NEPEAN HOSPITAL REDEVELOPMENT

SUMMARY OF AMENDMENTS – S455 MODIFICATION

LV 02 FLOOR PLAN

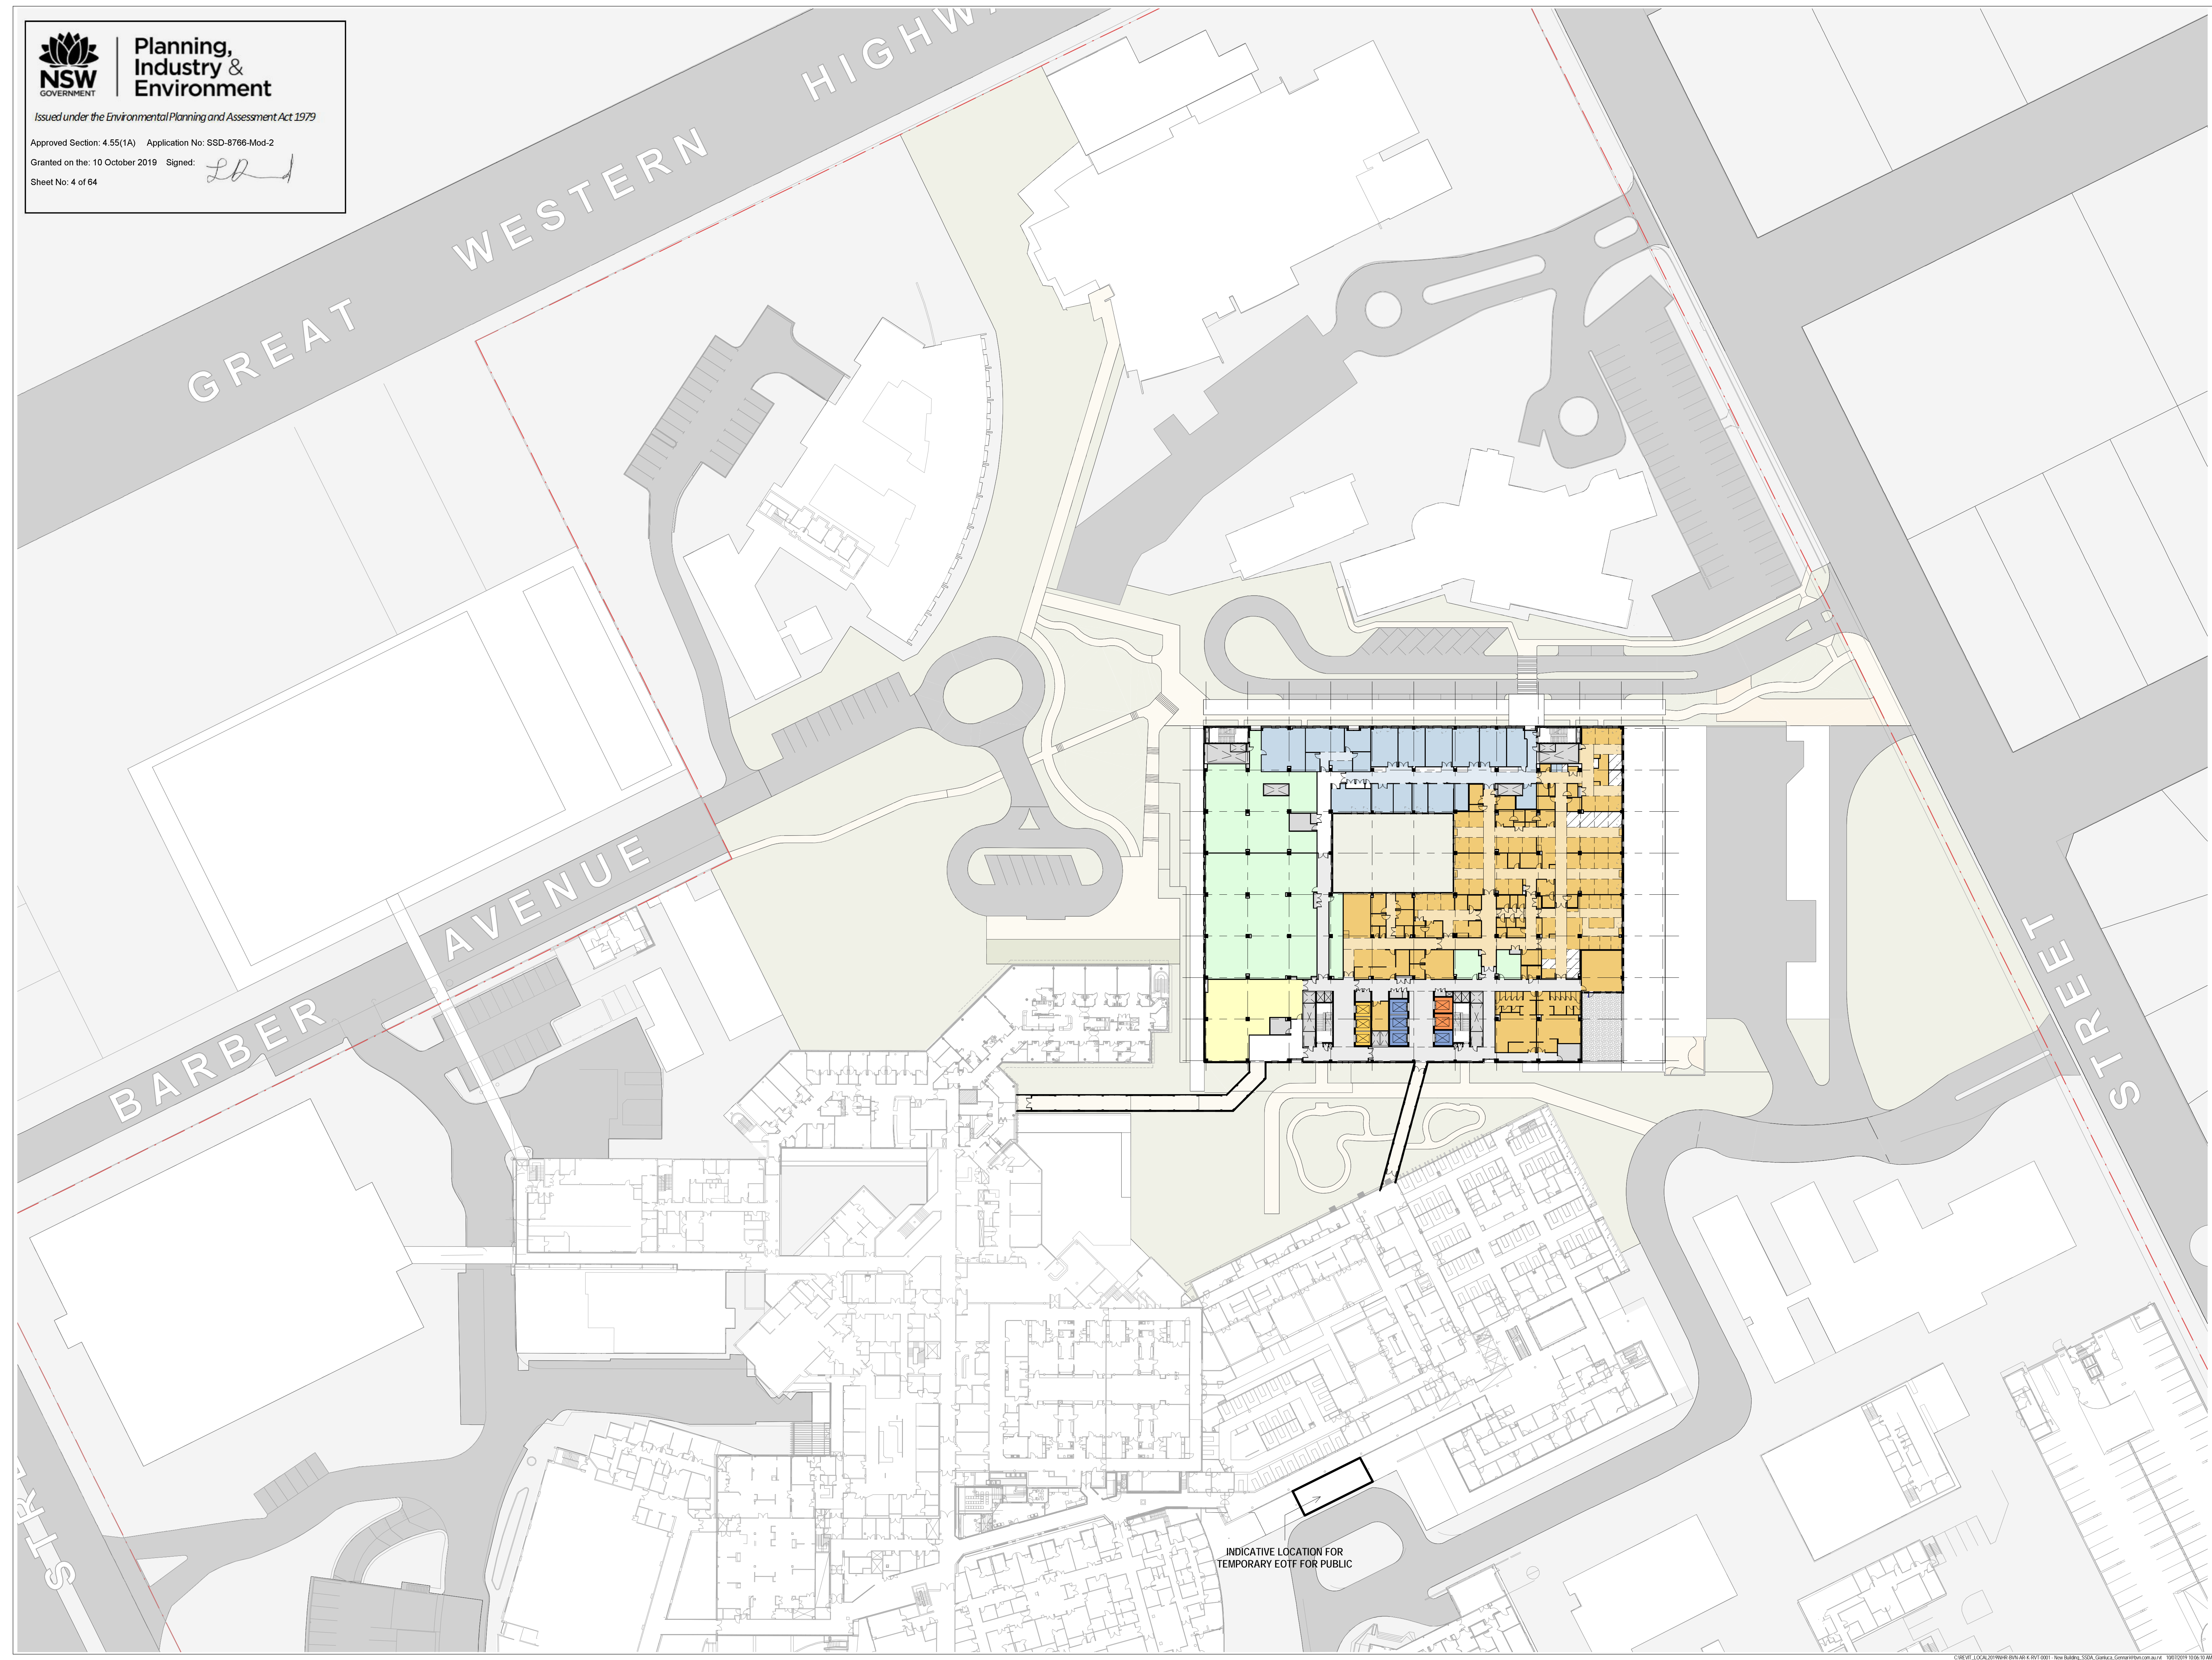
Lv 02 Floor Plan	NHR-BVN-AR-K-DWG-A0 - 202	C	Minor amendments to the clinical planning following the finalisation of the design. Landscape background updated to reflect current design. Roof of plant expansion in south east corner visible	Plant expansion to south east corner facilitates the inclusion of incoming communications plant located in close proximity to main core risers and on the incoming, street side of the development. Slight increase in the on floor mechanical plant enables efficient servicing of the adjacent birthing department
Lv 03 Floor Plan	NHR-BVN-AR-K-DWG-A0 - 203	C	Minor amendments to the clinical planning following the finalisation of the design. Landscape background updated to reflect current design	
Lv 04 Floor Plan	NHR-BVN-AR-K-DWG-A0 - 204	C	Overall configuration of the floor remains generally consistent with earlier approval. Minor amendments to the internal plant layout to accommodate plant relocated down from L13 roof. Landscape background updated to reflect current design	The plant consolidation on L4 has allowed for improved efficiencies in the system design and reticulation of services. This has also removed bulk from the uppermost part of the building

LV 12 FLOOR PLAN

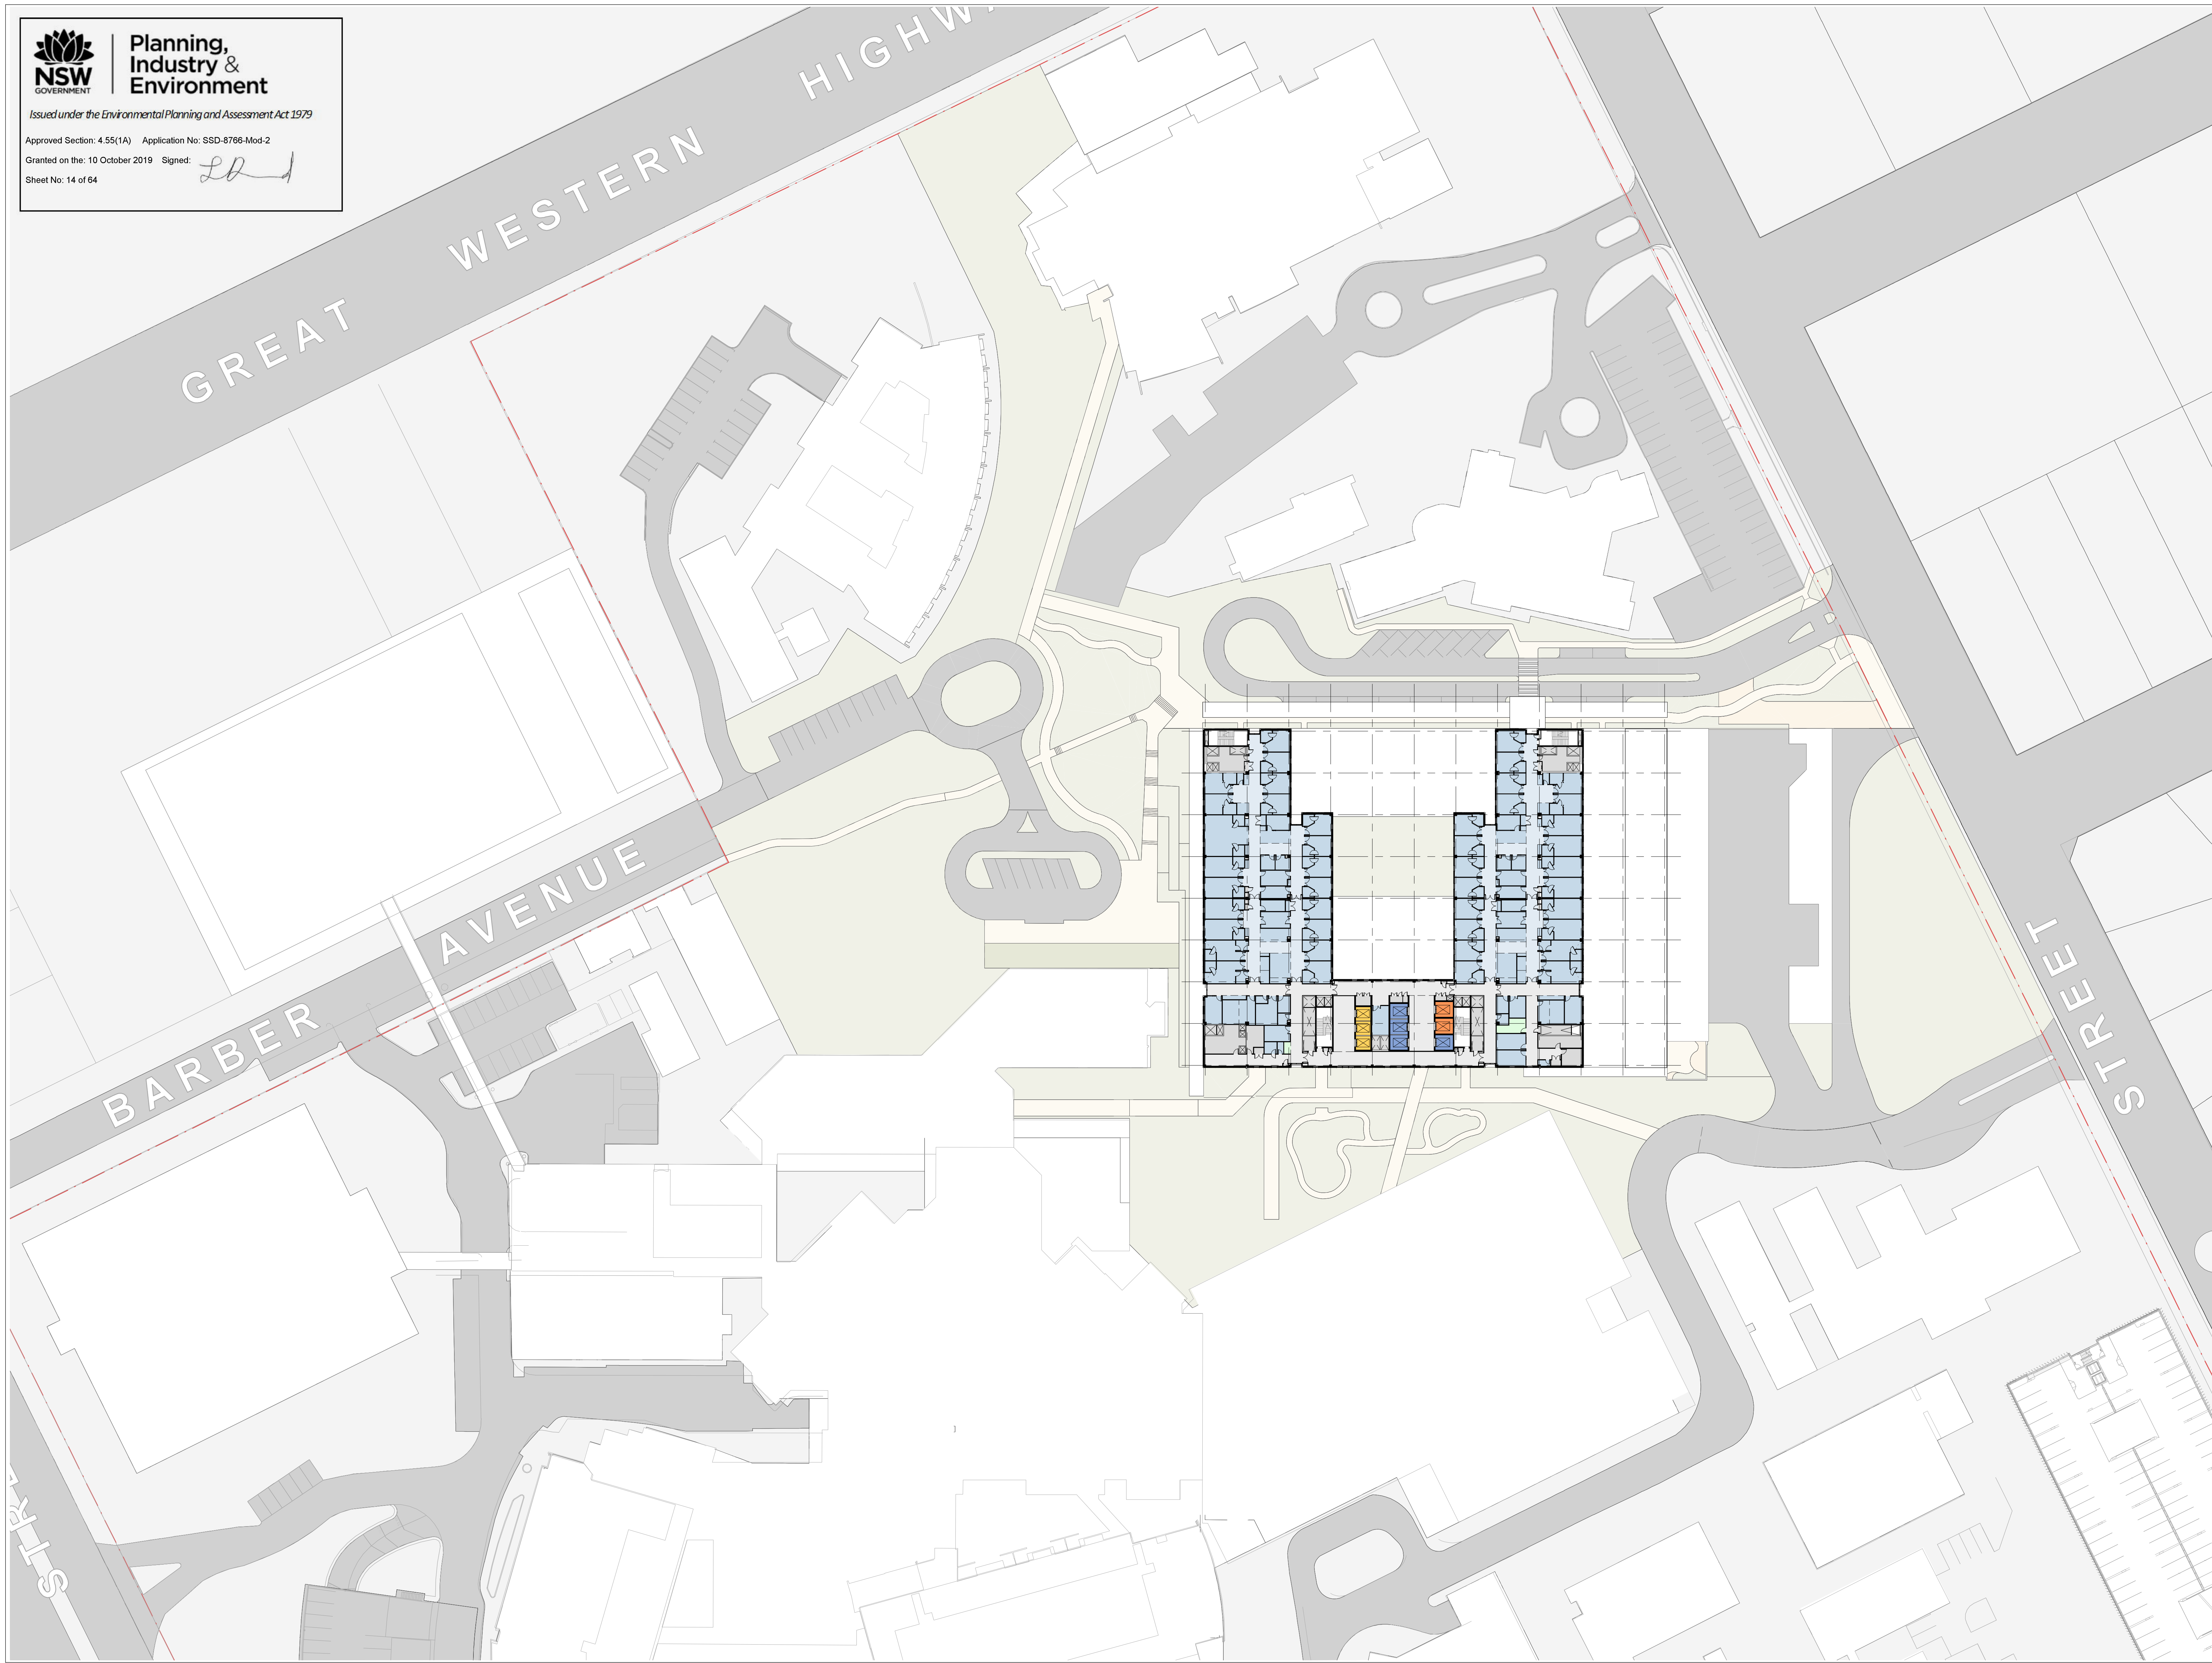
Lv 12 Floor Plan	NHR-BVN-AR-K-DWG-A0 - 212	C	Minor changes to on floor plan following ongoing design development, louvres no longer required for air intake. Landscape background updated to reflect current design	
Lv 13 Floor Plan	NHR-BVN-AR-K-DWG-A0 - 213	C	Reduction in extent of roof top plant with the majority now being consolidated on L4. The helicopter landing site reconfigured to minimise the visual impact. Landscape background updated to reflect current design	The plant consolidation on L4 has allowed for improved efficiencies in the system design and reticulation of services. This has also removed overall height & bulk from the uppermost part of the building. Plant remaining in place in the roof responds to the building diagram reinforcing the support spine. The helicopter landing site has been reconfigured to minimise the visual impact from as seen from below
Lv 14 Floor Plan	NHR-BVN-AR-K-DWG-A0 - 214	C	Lift lobby façade has been pushed north to facilitate improved viewing of the helicopter landing site. Reduction in extent of roof top plant with the majority now being consolidated on L4. The helicopter landing site amended to minimise the visual impact. Landscape background updated to reflect current design. Location of flues and other minor rooftop fixtures added.	The extension to the lift lobby allows for improved visual connection to the helicopter landing site improving safety and user functionality. The plant consolidation on L4 has allowed for improved efficiencies in the system design and reticulation of services. This has also removed overall height & bulk from the uppermost part of the building. Plant remaining in place on L14 responds to the building diagram reinforcing the support spine. The helicopter landing site has been reconfigured to minimise the visual impact from as seen from below
